# CITY OF PORTLAND, MAINE

**Project Name:** Munjoy Heights  
Six new buildings comprising 29 residential townhouses; one existing house on reconfigured lot

**Project ID:** 2013-228

On December 17<sup>th</sup>, 2013 the Portland Planning Board considered and approved a Level III Final Site Plan and Subdivision proposal to construct a 30 "lot" residential subdivision made up of 29 new units in six 3-4 story townhouse-style buildings and one existing residential building on a reconfigured lot.

DRAWING NO. **C-30**

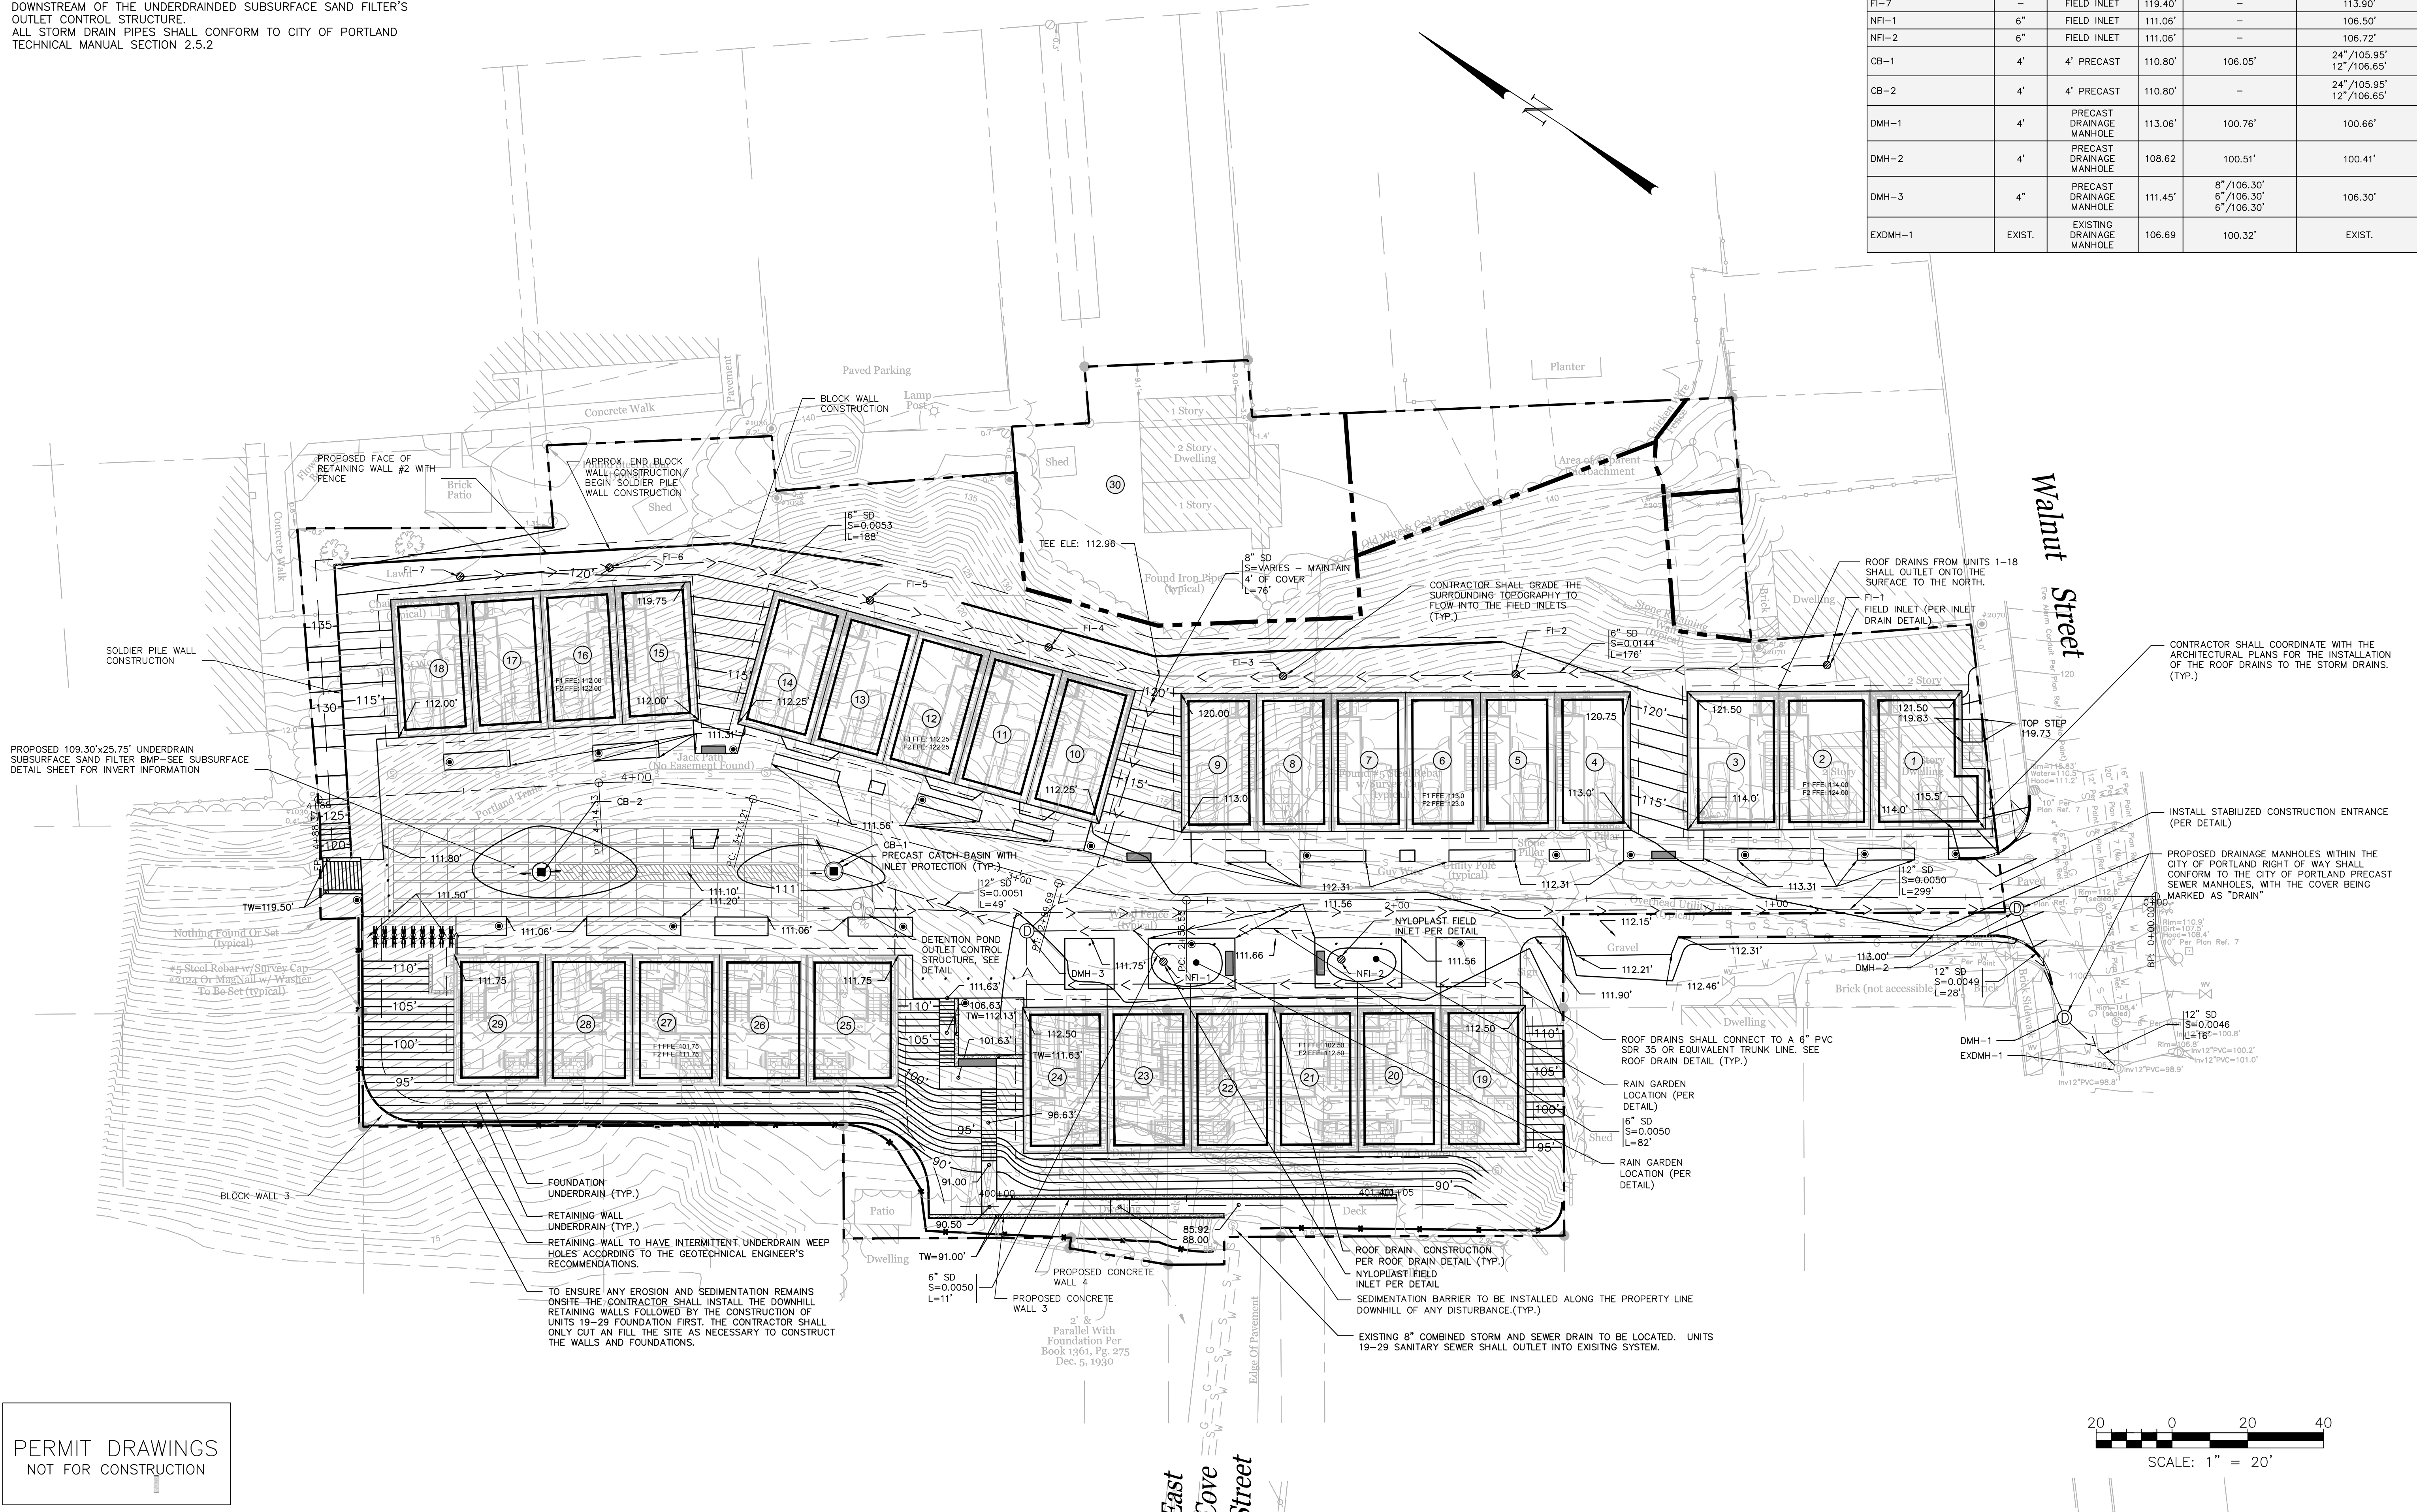
- v. That the applicant shall submit the revised civil engineering plans to confirm that the 20 foot access width in the central drive access is flush and constructed to withstand the weight of Fire Department vehicles and their outriggers for the entire 20 foot width over the entire length of the access drive, and to address the Engineering Review comments of Dave Senus dated 12.6.2013 items 2); 3); 12); 13); 17); 18); and 19); all for review and approval by the Planning Authority prior to the issuance of a building permit; and

SHEET TITLE: **RECON BLOCK-WALLS 1 & 2**  
**PLAN & PROFILE**

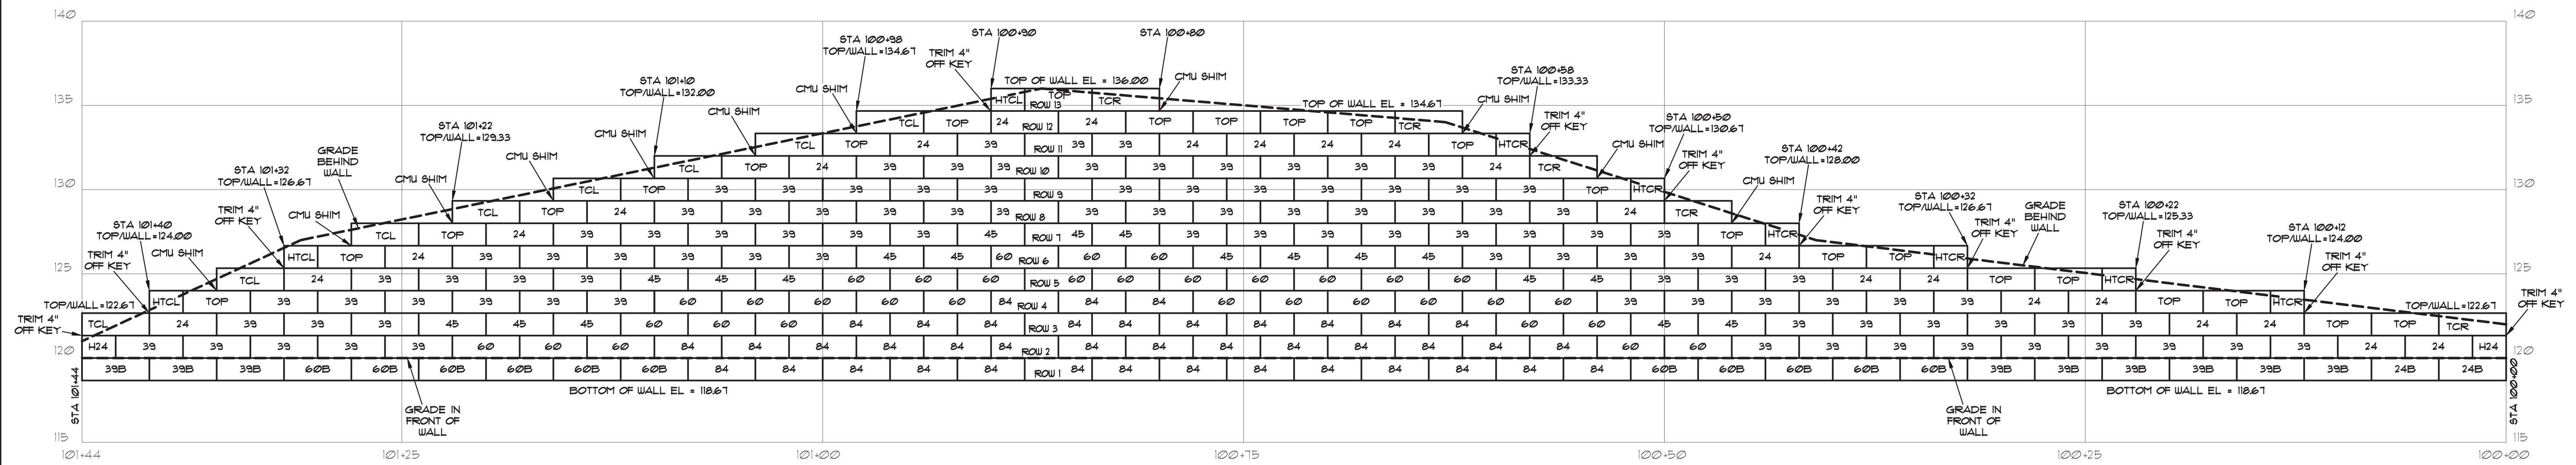
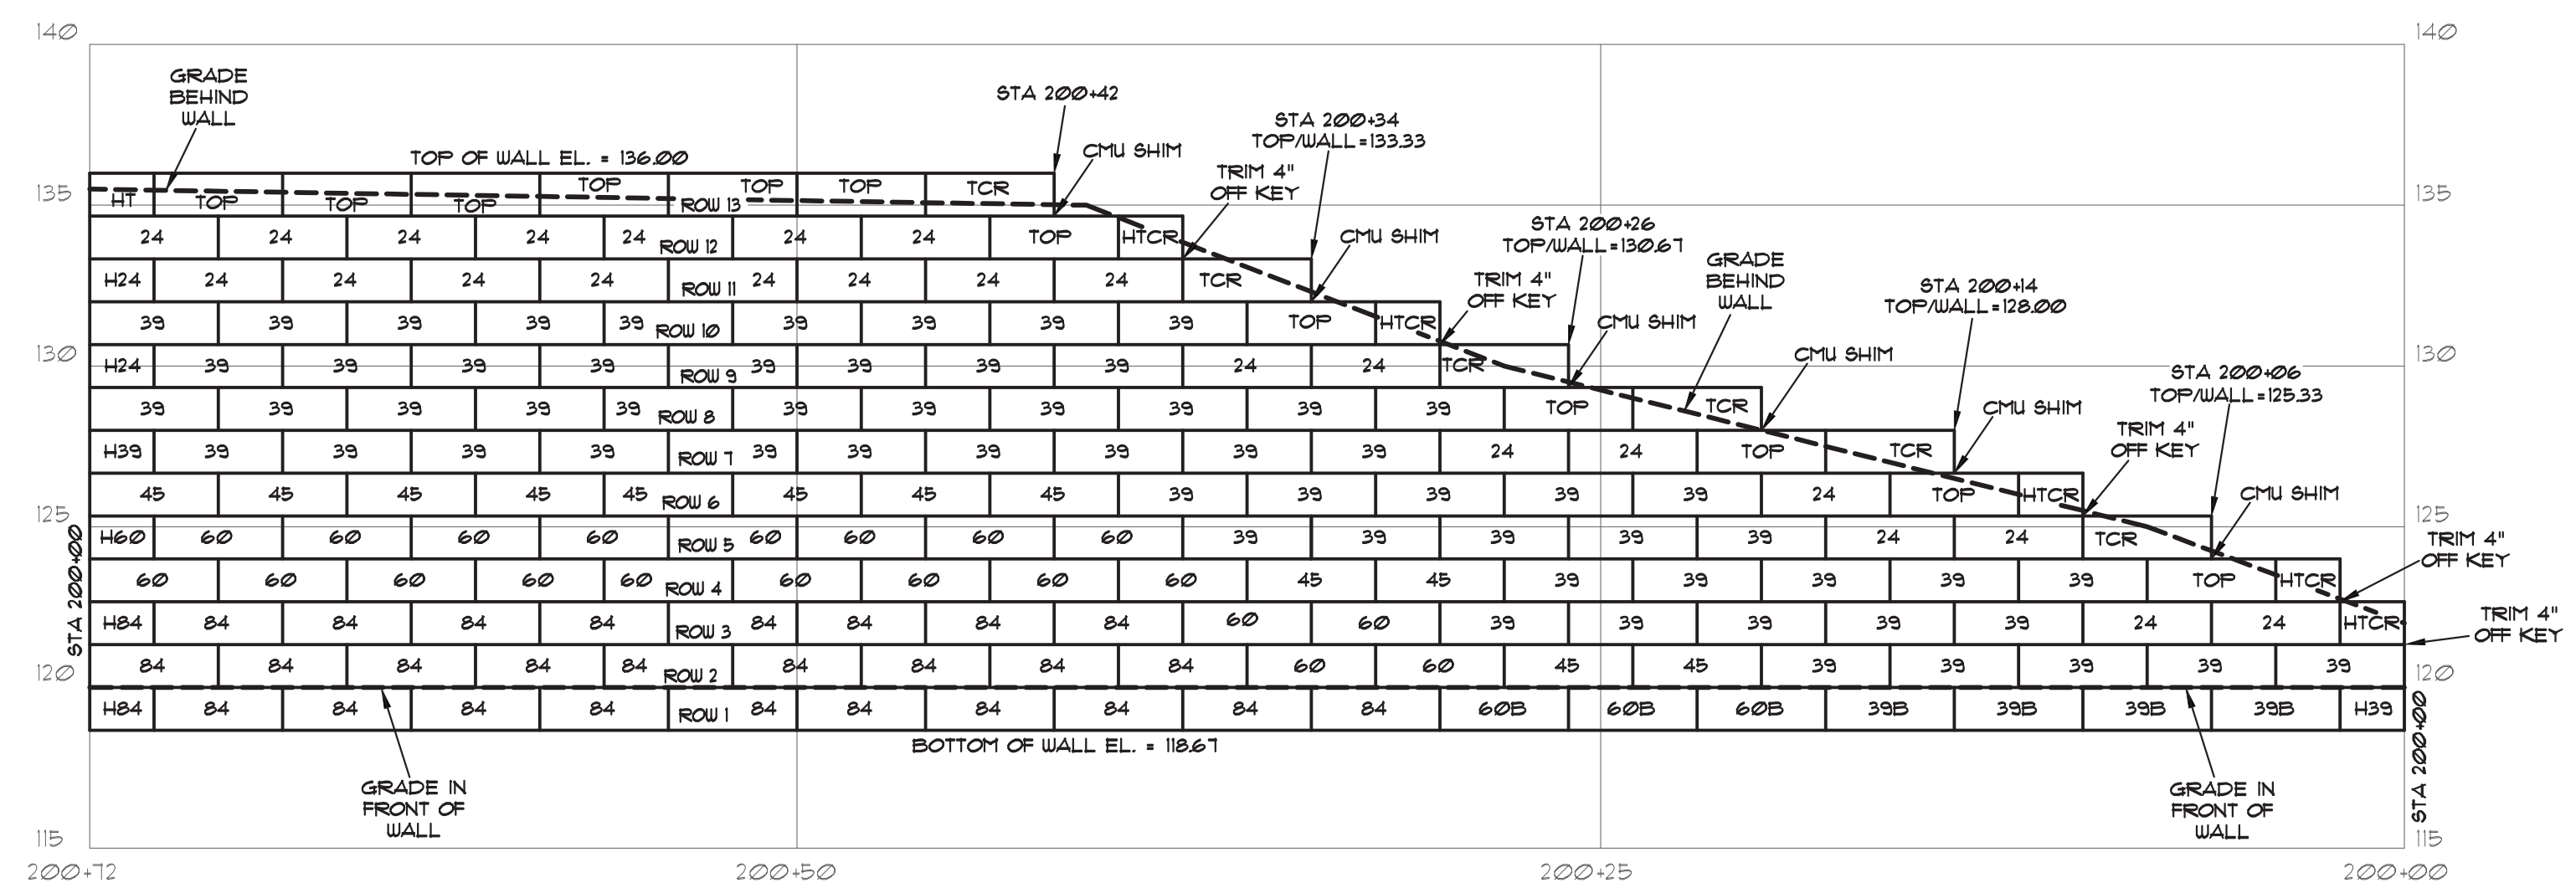
- vi. The applicant has noted on Plans Sheet C-32 & C-33 that Summit Engineering Services in coordination with Structural Integrity Consulting Engineers, Inc shall provide the retaining wall design, global stability analysis, and the design of the temporary soil restraint measures, as required. The referenced retaining wall designs shall be completed, stamped by a professional engineer, and submitted to the City of Portland Inspections Department and Planning Authority as part of the Building Permit process prior to construction of any retaining walls; and
